**WEST SUSSEX COUNTY COUNCIL
STRATEGIC PLANNING CONSULTATION**

SUBJECT: LU/385/14/PL - Construction of a solar energy park to include the installation of solar panels, security fencing, transformer housing, access and other associated works

LOCATION: Land at Brookbarn Farm, Courtwick Lane, Littlehampton, BN17 7PX

This is the WSCC highways and transport response to the planning application.

APPLICATION SITE ACCESS AND ON-SITE VEHICLE ARRANGEMENTS

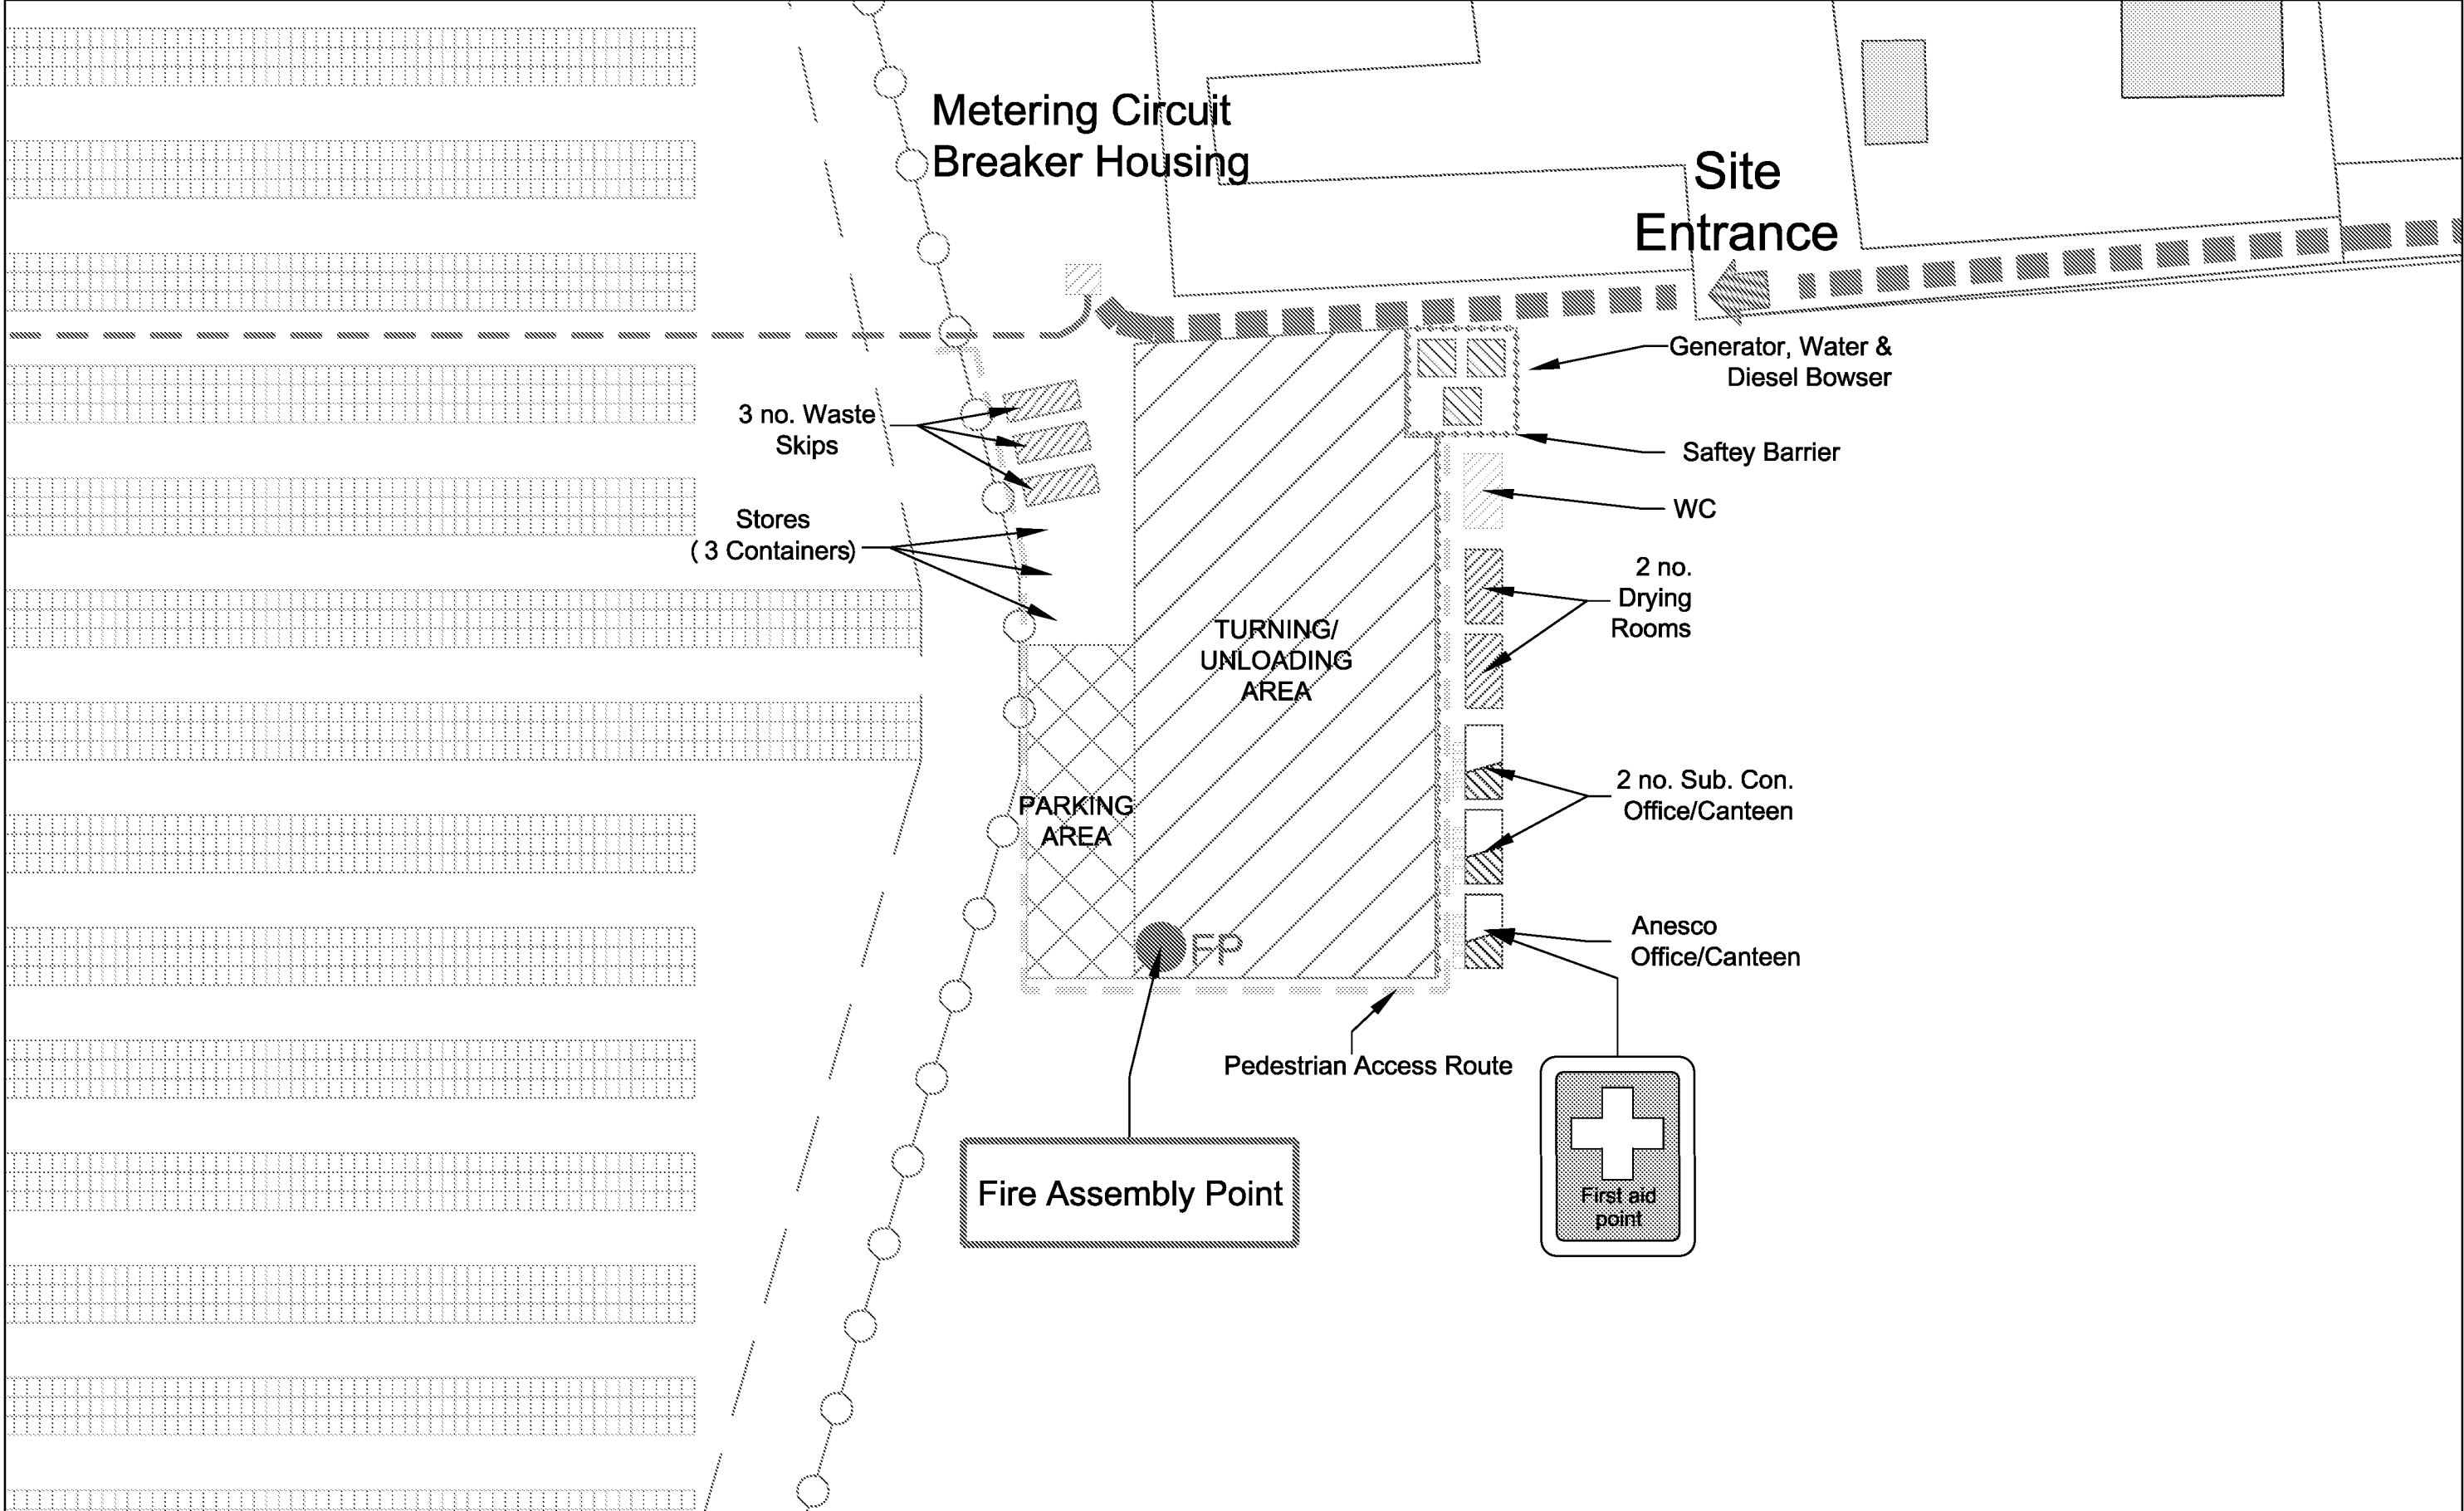
The applicant proposes access to be off the western-most section of Old Mead Road. Other than an indicative arrow and dashed line, no specific detail is shown. If planning permission is granted, a requirement to provide a detailed site plan showing access should be secured. Likewise, this should also be provided for the construction compound.

A compound is shown on the application drawings for use when the site is being constructed. As an observation, this appears to be outside of the application site boundary (red edging). It is the applicant's responsibility that this area can be provided as part of the planning application (and provided when the site is dismantled when the use ceases).

1. **Access to site (permanent – post construction)** – Access to the site shall be from Old Mead Road only, in accordance with detailed plans to be submitted to and approved by the LPA after consultation with the CHA. Thereafter, it shall be retained for its intended purpose.

2. **Parking and turning (permanent – post construction)** - No development, hereby approved, shall be occupied until provision for parking, turning, loading and unloading of vehicles associated with the development clear of Old Mead Road and any adopted highway has been provided in accordance with plans to be submitted to and approved by the LPA after consultation with the CHA. Provision should thereafter be maintained solely for the purpose of the parking and turning of vehicles clear of any adopted highway and Old Mead Road.
